Rezoning Transportation Analysis

Petition Number: 2020-168

General Location Identifier: Tax ID 10110157

Rezoning Transportation Analysis

SHEET NO:
RZ-1

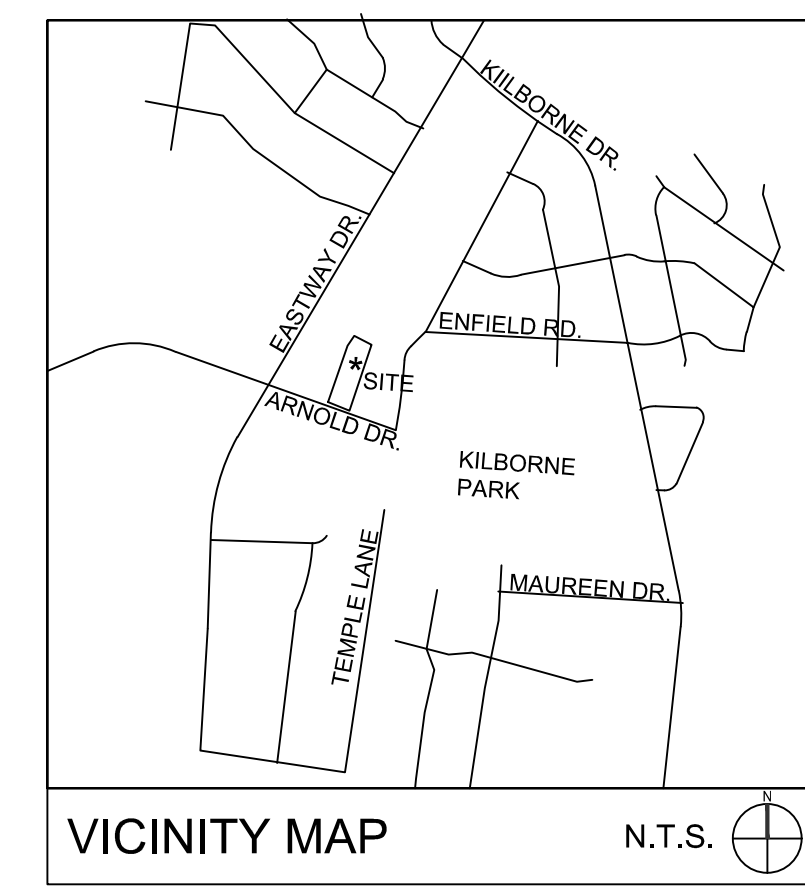
- a. ~~Arnold Drive: The curb and gutter needs to be installed at 17.5 feet from the road centerline.~~

~~Label and dimension the curb and gutter from the centerline for each road to the back of curb on the site plan. Resolved (3/23/21)~~

3. ~~Revise site plan and conditional note(s) to commit to dedicating 25.5 feet of right-of-way, to be measured from the road centerline. Label and dimension the right-of-way from the road centerline. Resolved (3/23/21)~~

4. ~~A site plan note(s) specifying dedication and fee simple conveyance of all rights-of-way to the City before the site's first building certificate of occupancy is issued is needed. CDOT requests rights-of-way set at 2' behind back of sidewalk where feasible. Resolved (3/23/21)~~

5. ~~A site plan note specifying that all transportation improvements will be approved and constructed before the site's first building certificate of occupancy is issued is needed. The petitioner may phase transportation improvements if said improvements and phasing are explicitly described in site plan notes. Resolved (3/23/21)~~
